REQUEST

Current Zoning: N1-A (neighborhood 1-A)
Proposed Zoning: CG(CD) (general commercial, conditional)

Approximately 3.85 acres located at the southwest intersection of Oakdale Road and Mt. Holly-Huntersville Road, north of Interstate 485.

The petition proposes a neighborhood shopping center with up to 31,500 square-feet of commercial/retail space as allowed in the General Commercial Zoning District.

SHEET
SITE PLAN

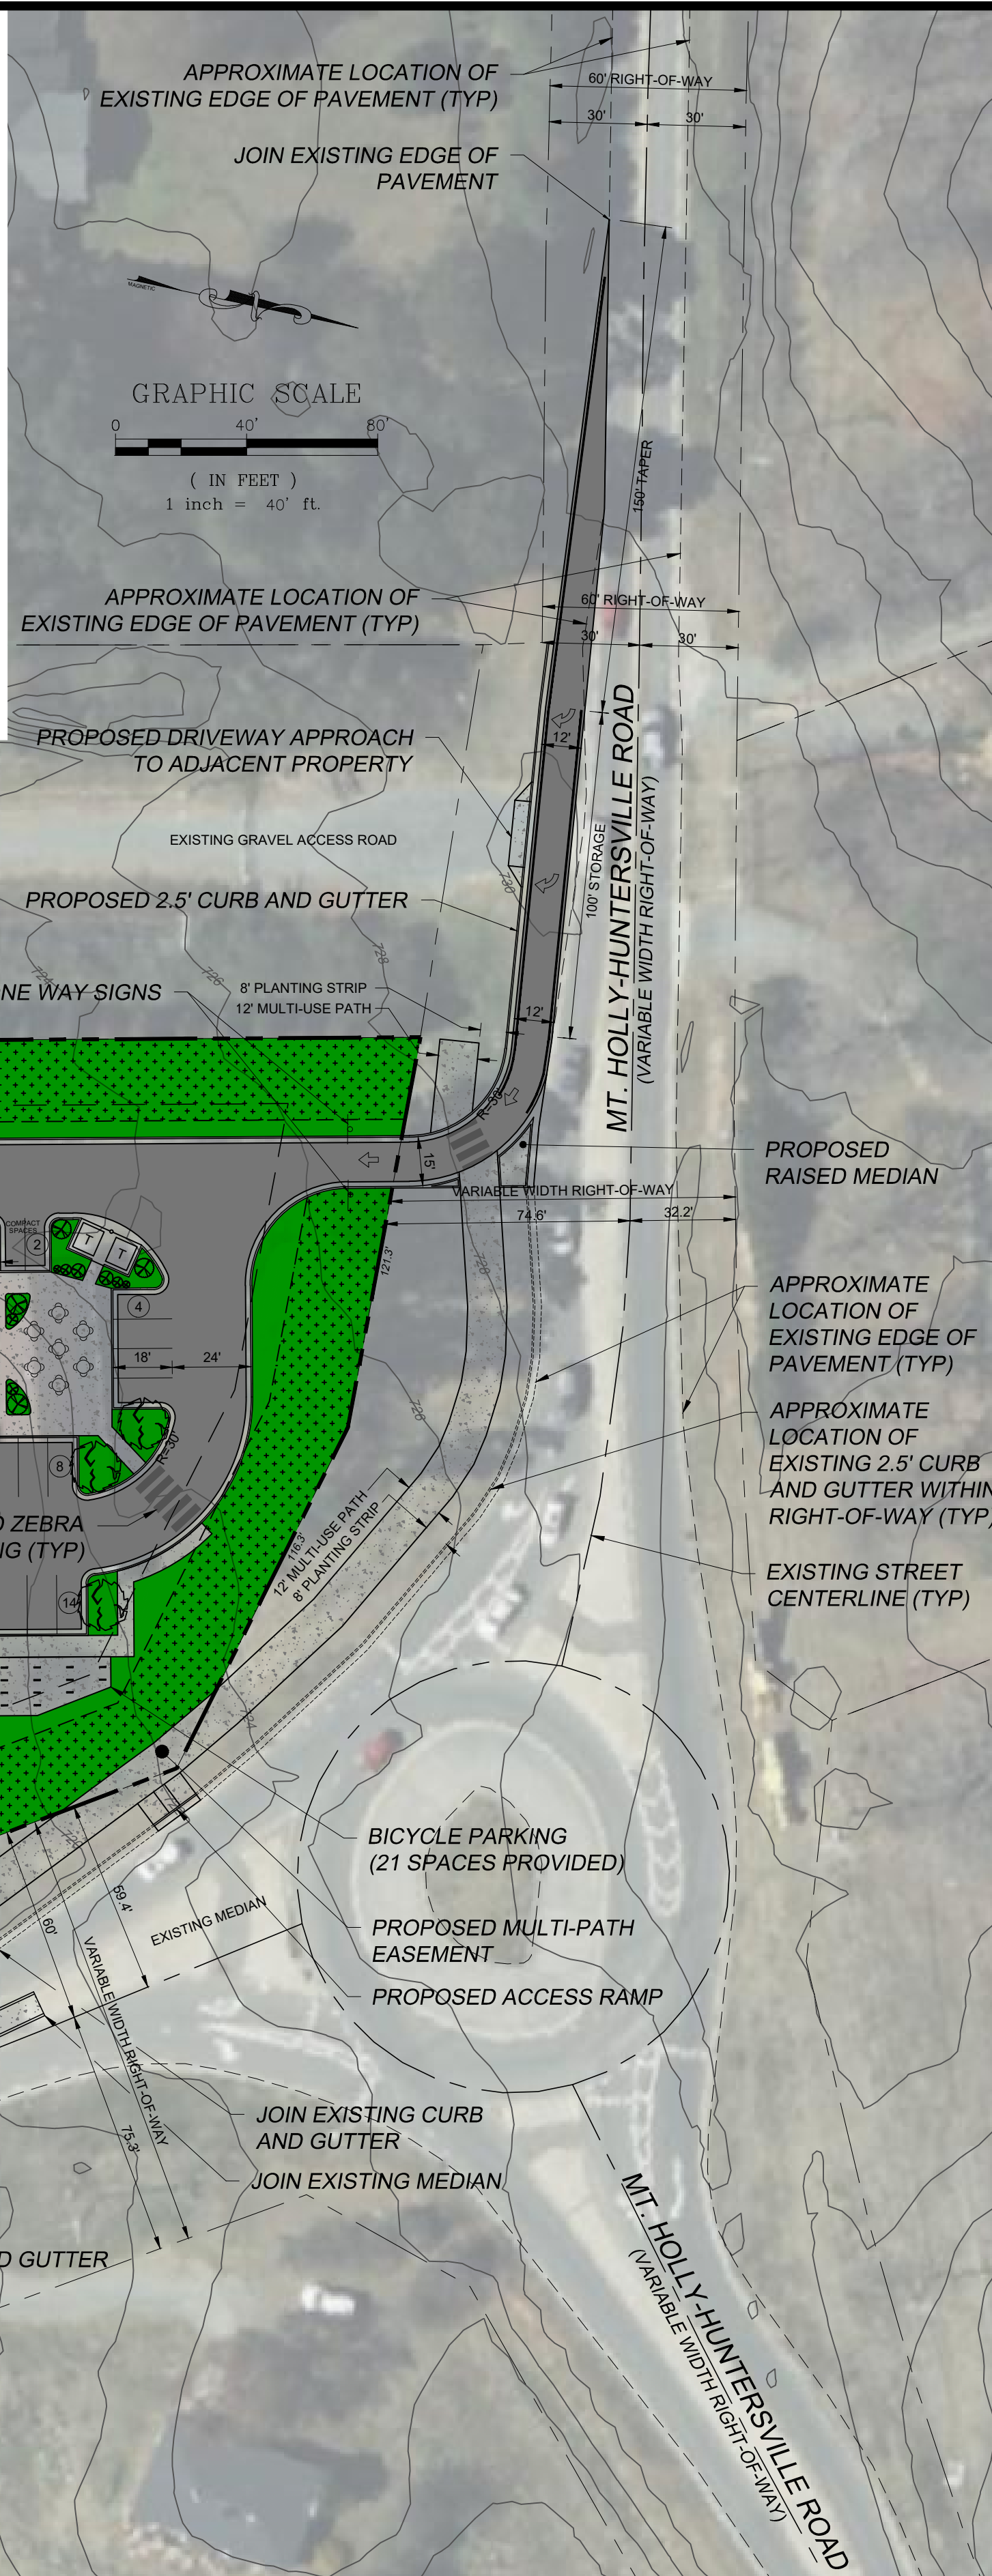
1. ~~Complete CTR summary table and include on the revised plan.~~ Addressed

2. ~~Tree save needs to be shown on the plans in a way that meets the ordinance. Tree save must be comprised of existing protected tree canopy.~~ Addressed
